Development Control  
Ribble Valley Borough Council

**Re:** Planning Application 18/0786

**Address:** Dog and Partridge Hesketh Lane Chipping PR3 2TH

**Description:** Conversion of an existing restaurant (A3) to create twelve apartments (C3) and the siting of four holiday lets.

# PROPOSED BLOCK PLAN

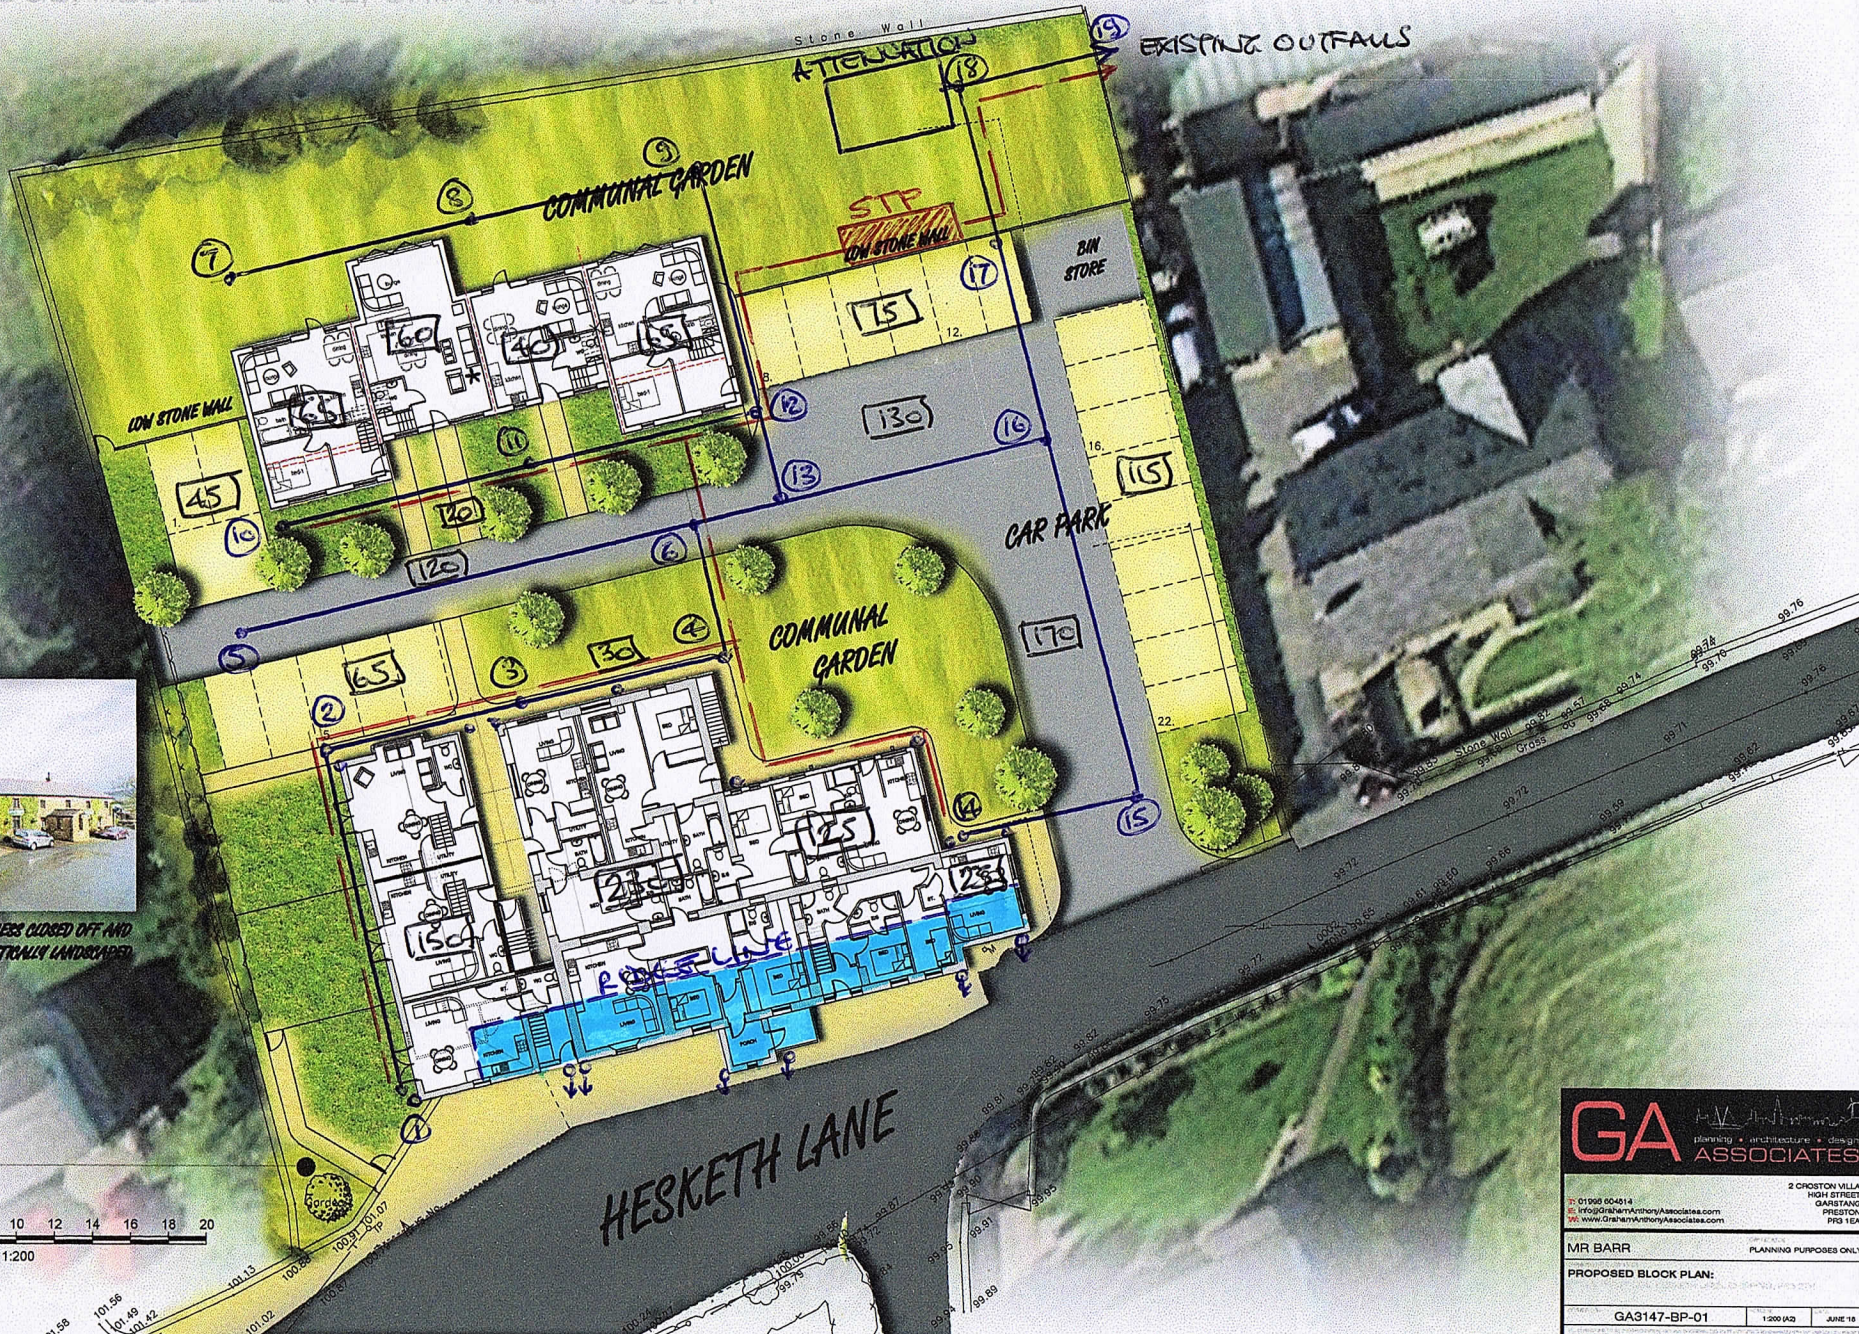
Although there is some cycle parking shown on the plan, there are is no indication as to its precise nature, additionally the location of some units near to the entrance would be a security risk. The cycle storage provision is expected to be a cycle locker rather than a communal covered rail.

Whilst a swept path analysis has ensured that the refuse collection vehicle can enter and leave the site in a forward gear, there is a concern regarding the functionality of car parking spaces 5 – 7, further swept paths are required to ensure their functionality. The Department of Transports document Manual for Streets, Sections 8.3.50-2 gives guidance regarding the access to parking bays, it would be expected that a gap of 6m would be required to allow vehicles reverse in or out of the car parking spaces.

It is expected that a Section 278 agreement will be entered into to ensure that the new kerb line across the old entrances and the new section of footway adjacent to the entrance that is to be retained.

2. This consent does not give approval to a connection being made to the County Council's highway drainage system.
3. The position and nature of the cycle storage will need to be agreed with the Local Planning Authority in conjunction with the Highway Authority.
